From: [Mark Peacock](#)
To: [Planning](#)
Subject: FW: Hatfield. KFC Former De Haviland Building, Comet Way.16/1007/FUL, 1008/ADV, 1089/LB
Date: 06 August 2016 09:05:43

From: Andrew Robley
Sent: 05 August 2016 18:35
To: Mark Peacock
Subject: Hatfield. KFC Former De Haviland Building, Comet Way.16/1007/FUL, 1008/ADV, 1089/LB

**existing elevation F**  
scale - 1:50 @ A1 / 1:100 @ A3

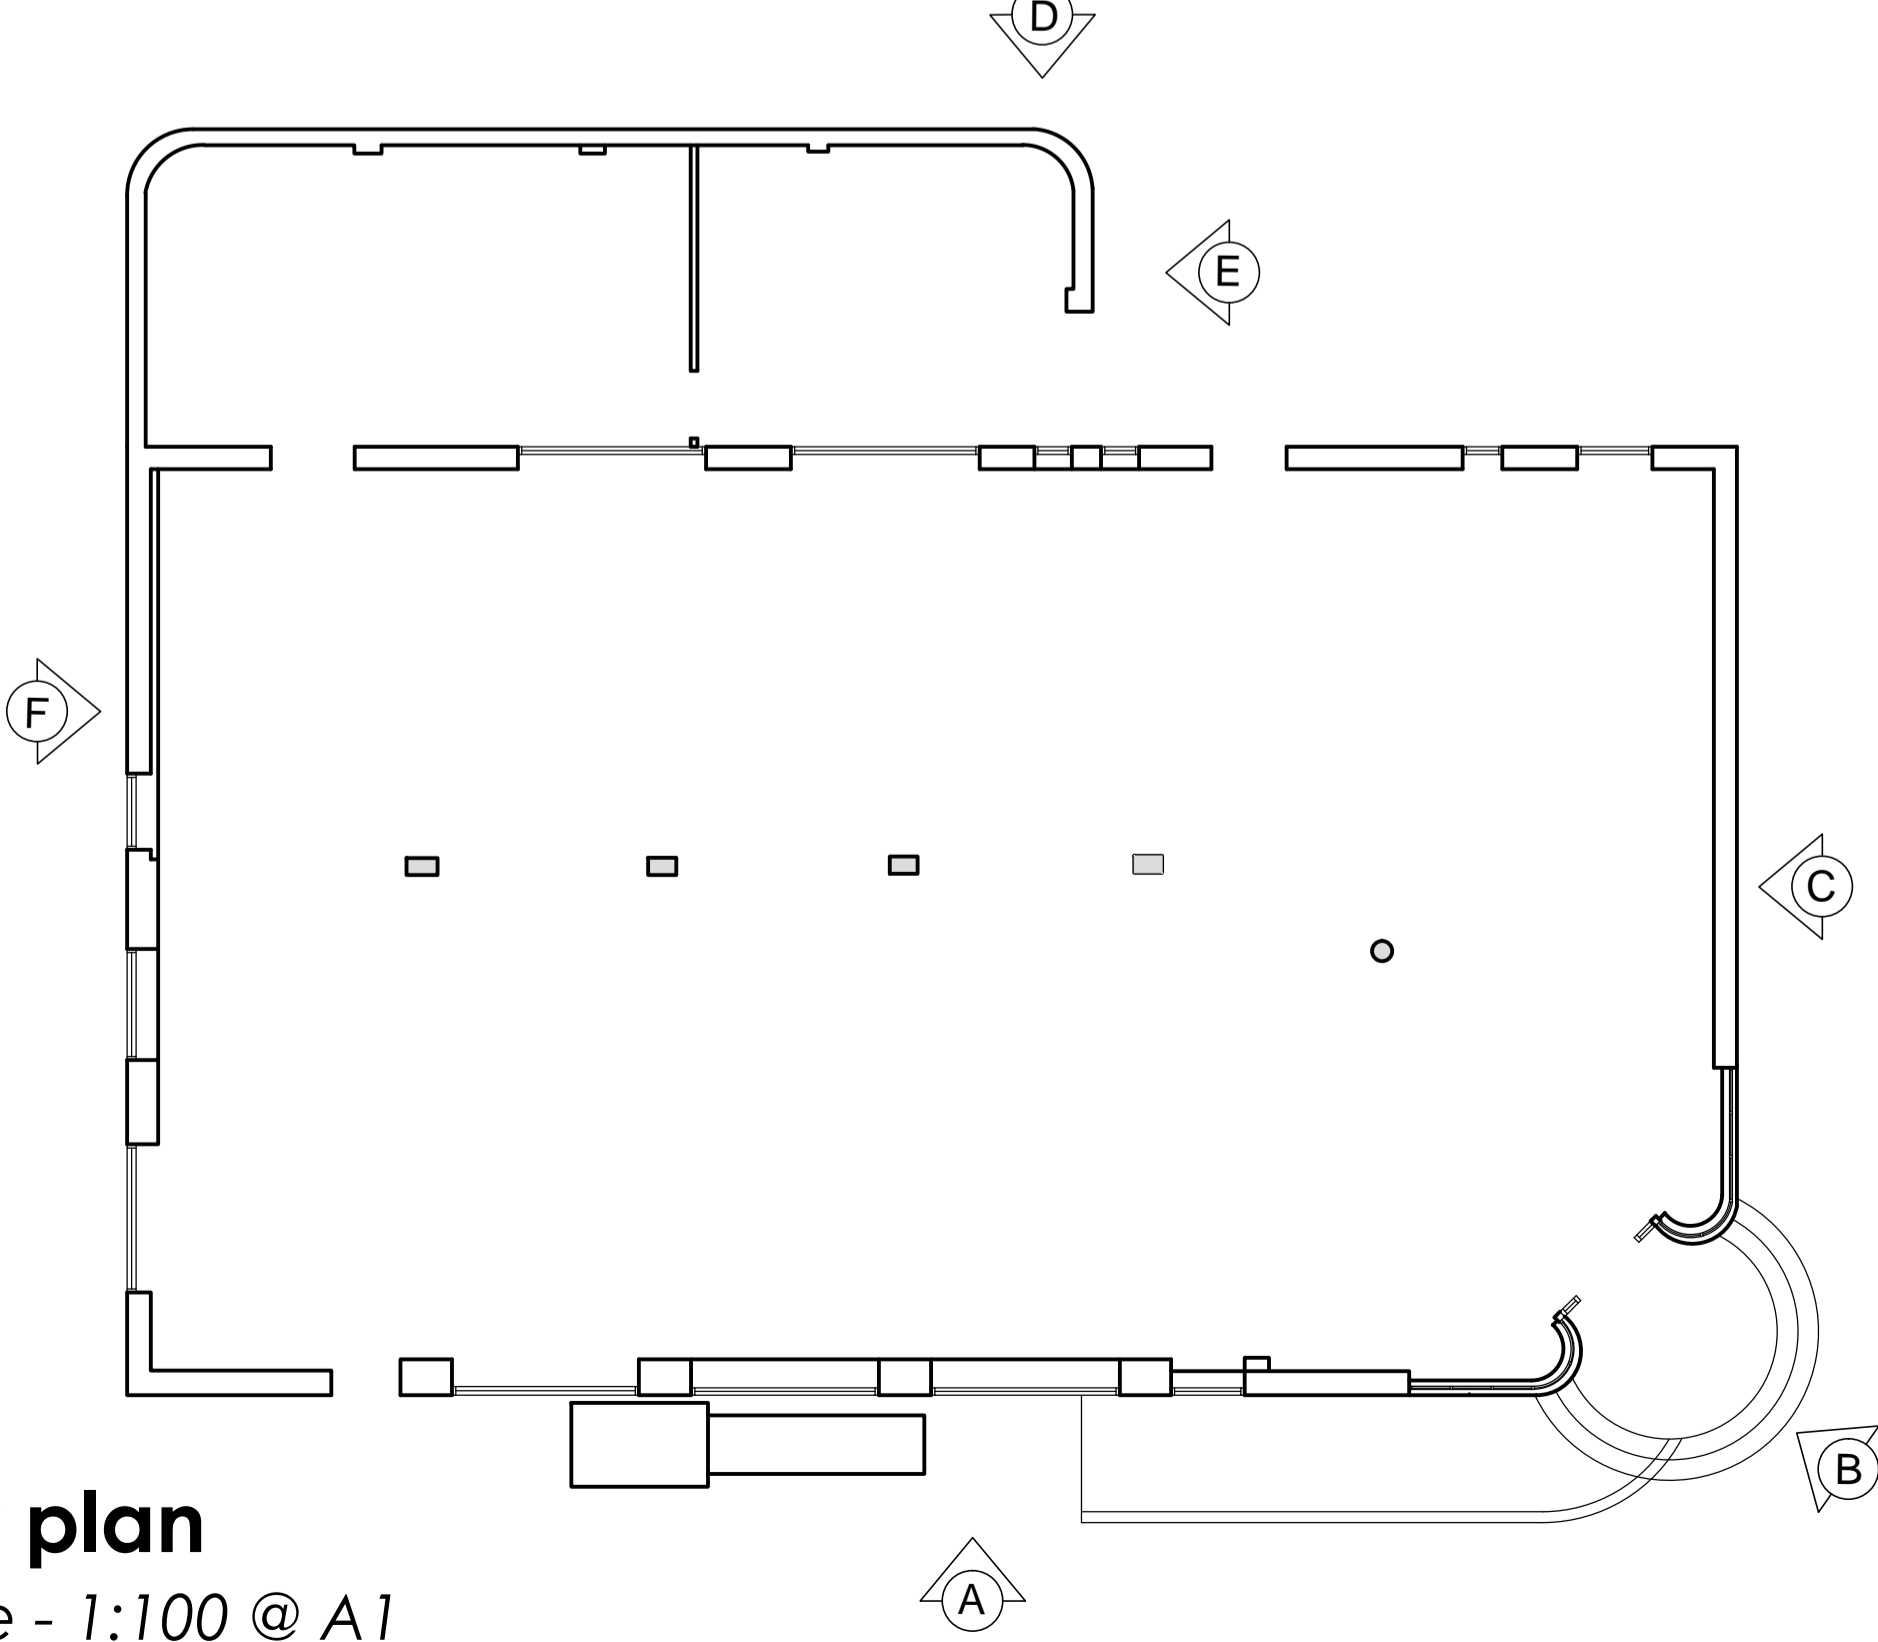
I can't see any changes on the building except for respraying windows, doors and spandrels the same colour green. This is Ok but the green must be exactly the same. However the "Drive Thru frames" would be sprayed an unacceptable red. On the building they must be the same green or if they must have a contrast, the grey RAL7022 they are using elsewhere.

The doors that are shown to be resprayed the same colour as at present would be better in the same green but if they already have consent in the darker colour it is reasonably acceptable.
